Ref 2312.corr.RVBC241025

**2312 Springs Barn, Old Nab Road, Langho, Blackburn, BB6 8DY**

This application follows a previous planning application ref.3/2024/0355 for a flat roof extension to the existing dwelling that was refused. Following the refusal, Stanton Andrews have engaged in informal discussions with the planning officer, Kathryn Hughes, to develop a scheme that suits the applicant's brief that would be agreeable to the local authority.

name
elevations sheet 1 of 2

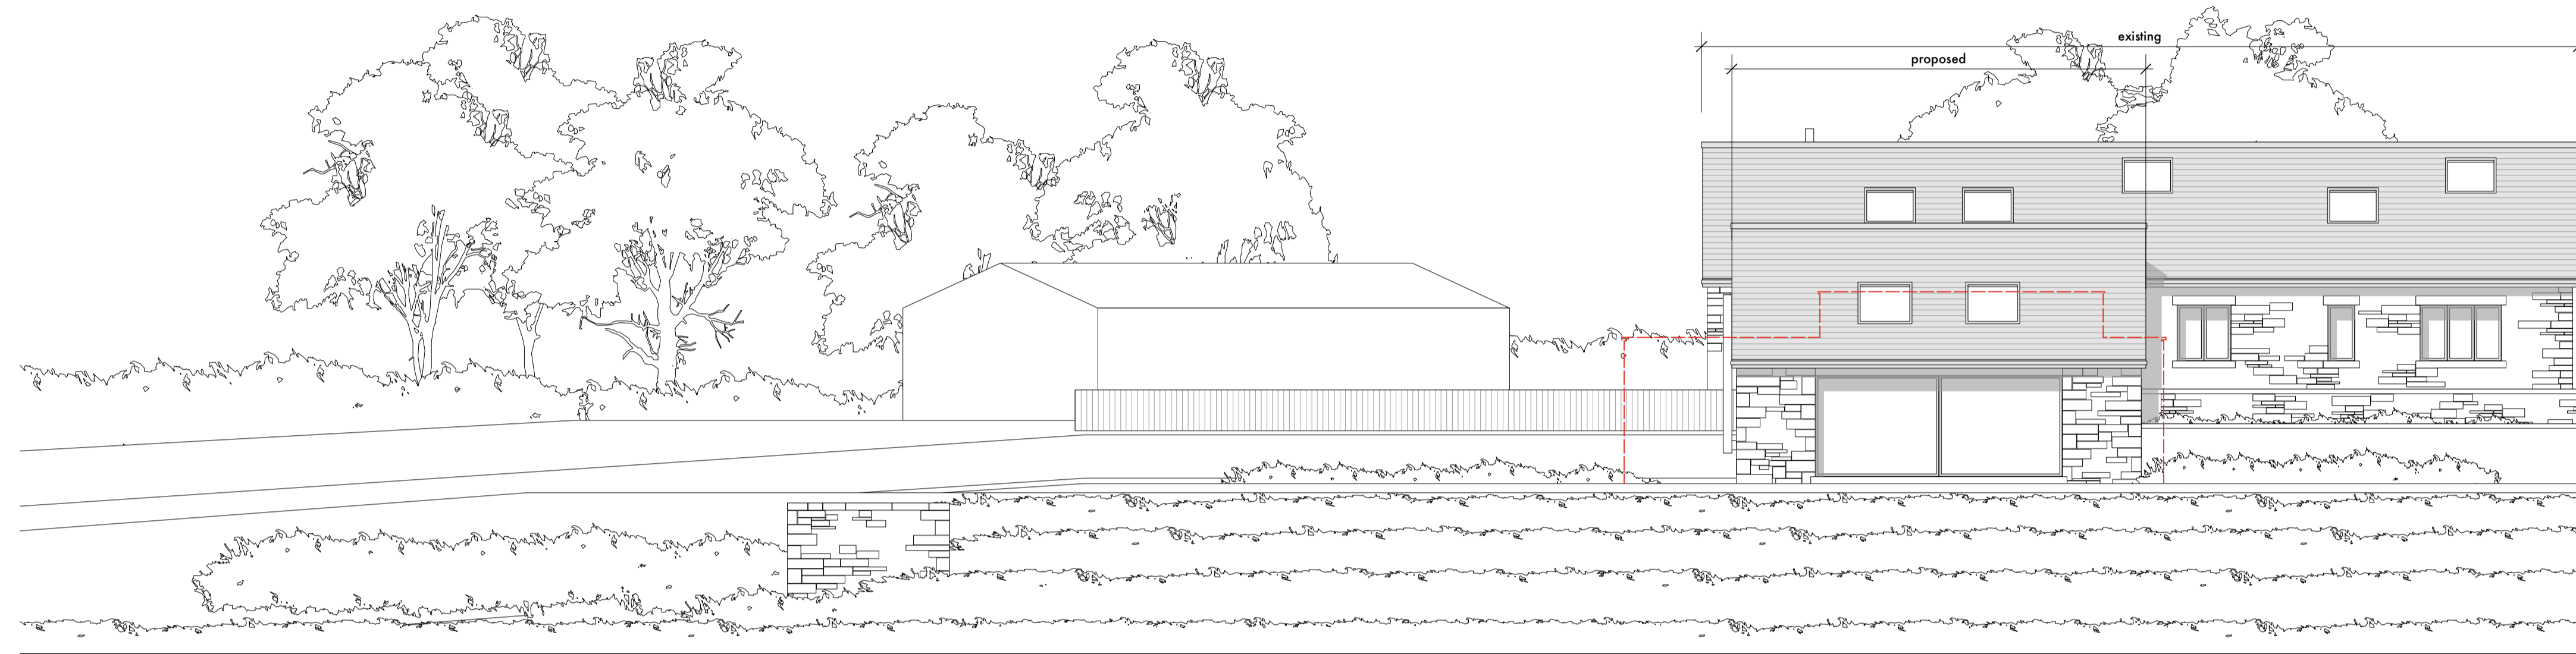
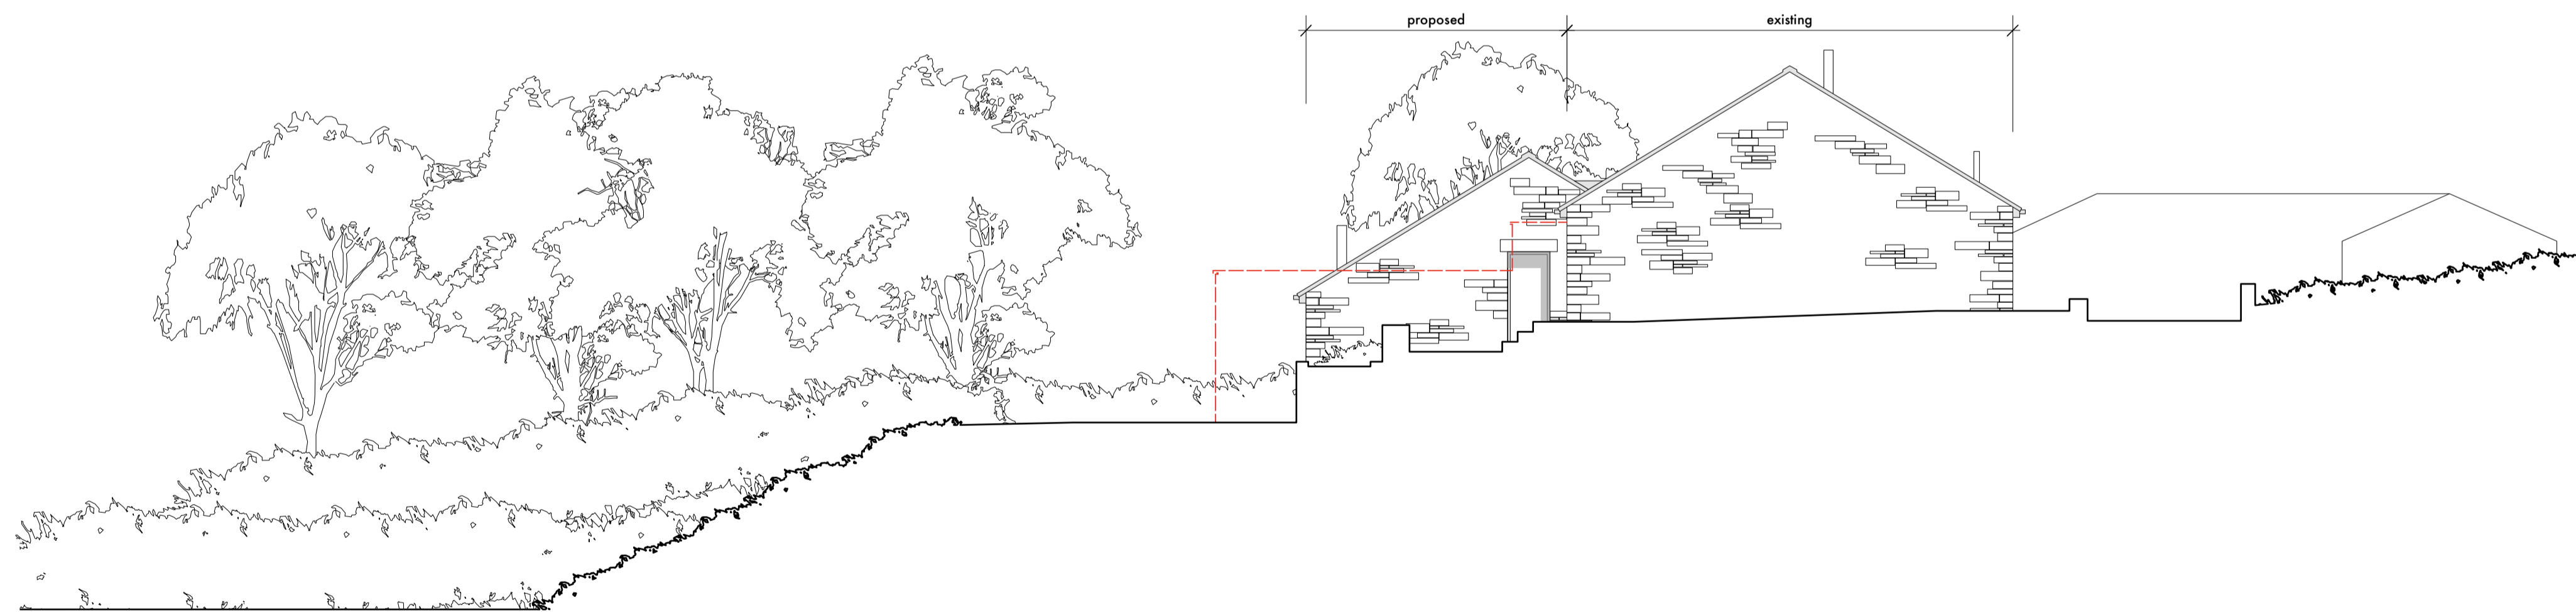
*'The proposed extension would not be sympathetic to the linear form of the barn conversion. The single storey extension sited on the lower ground garden level would result in an overly bulky and prominent addition, out of character with the original barn structure with the extent of glazing inappropriate in design and visual terms. In particular the flat roof feature contributes to the overall impact on the barn conversion and would result in a detrimental impact upon the character and appearance of the barn conversion. Together with the introduction of large, glazed opening to the southern gable and eastern elevation would reduce the solid to void ratio to an unacceptable degree.'*

6. *'The proposed extension and insertion of large glazed elements to the barn conversion in the form of a glazed link and the bulky single storey flat roofed element would not be appropriate in terms of design and visual impact and therefore do not accord with Key Statement EN1 and policies DMG1 and DMH4.'*

The projection of the proposed extension has been reduced considerably from the previous scheme, with the proposed extension now set back from the existing terrace and planted areas to the east of the property. Moreover, the previously proposed large, glazed opening to the southern gable has been removed. The existing window to this elevation is to be amended to suit the proposed internal layout. The proposed opening will be the same width as the existing window it is replacing, this should address the concerns regarding the 'solid to void ratio'.

The glazed link has been removed and the proposed glazing to the eastern elevation has been reduced in order to address this comment. The 'bulky single storey flat roofed element' has been removed in favour of a gabled roof form as described above.

project	spring barn	project number	23.12
name	elevations	sheet 2 of 2	
scale	1 to 100 @ A1	date	october 2024
		note	planning
		revision	A

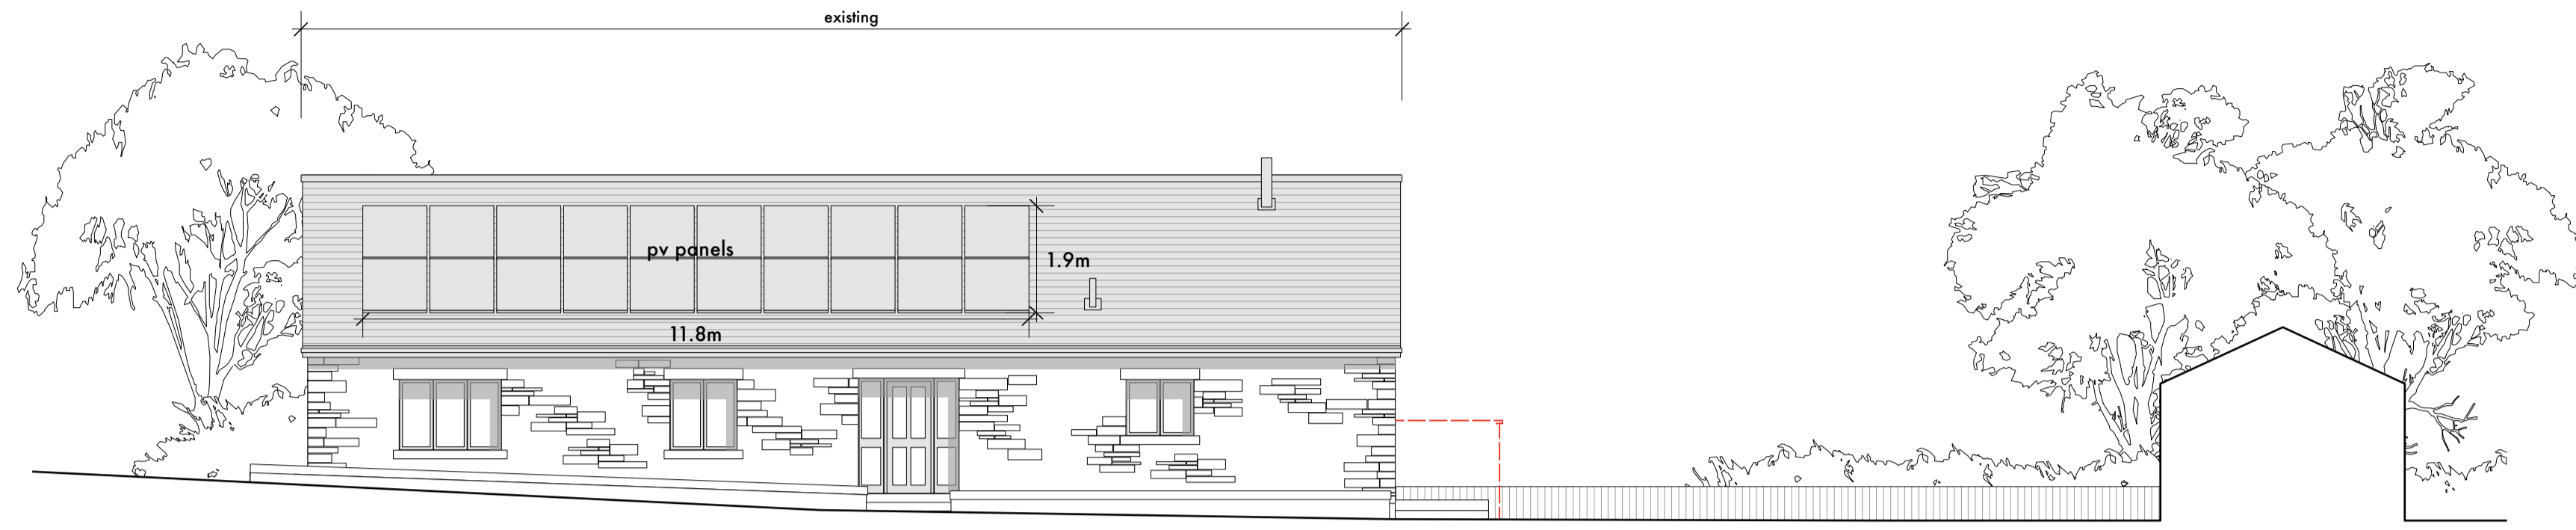
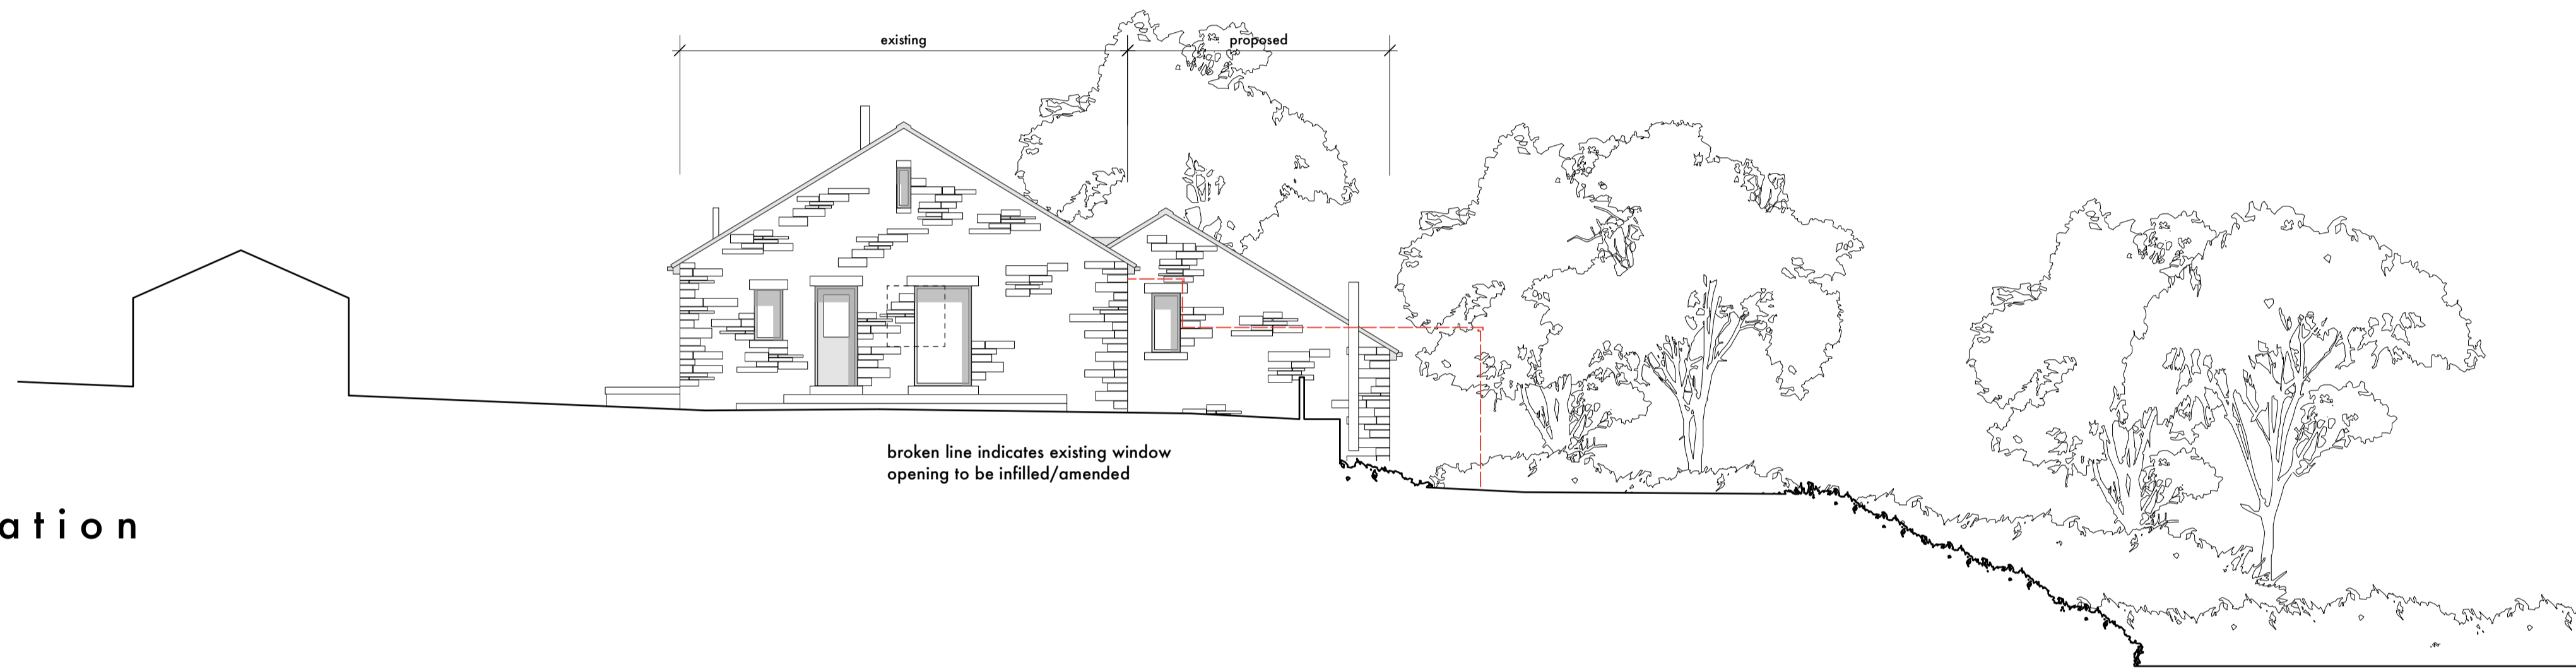
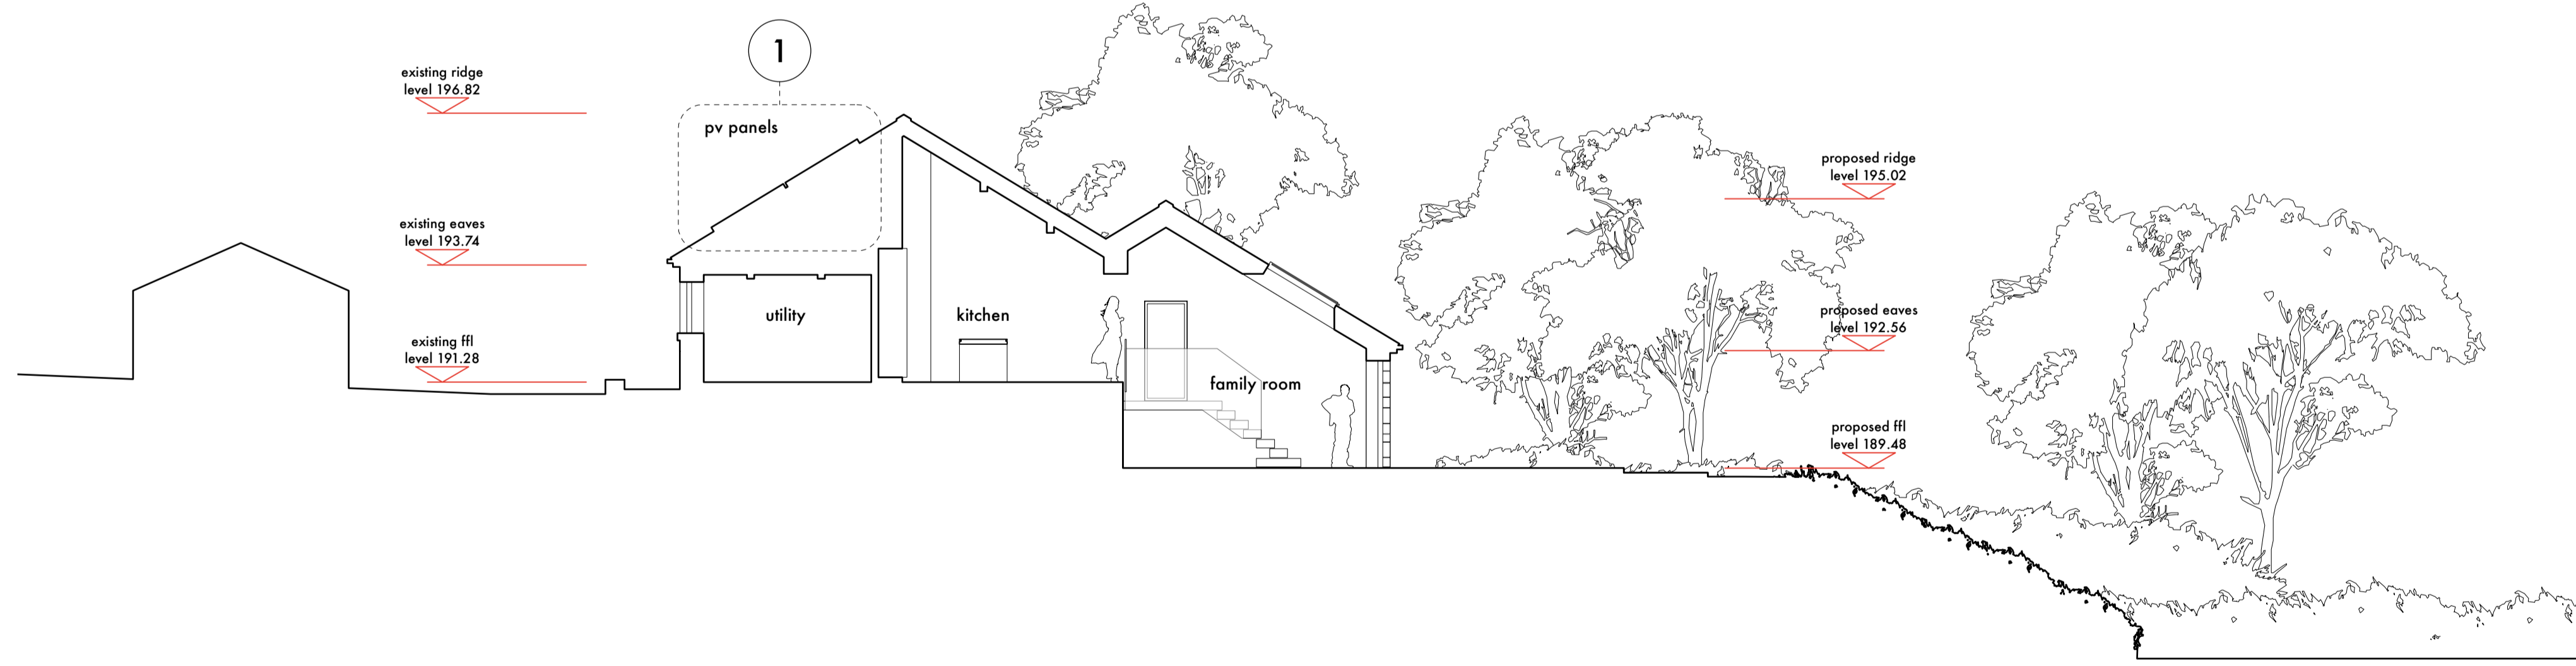
2. *'It is further considered that the proposed flat "green roof" would not mitigate for the resulting harm and whilst this reduces the volume of the extension the overall design is incongruous and out of character for a barn conversion and therefore is inappropriate development contrary to NPPF para 154 (c).'*

The flat roof of the extension has been removed in favour of a gabled roof form that mirrors the pitch of the roof to the existing property.
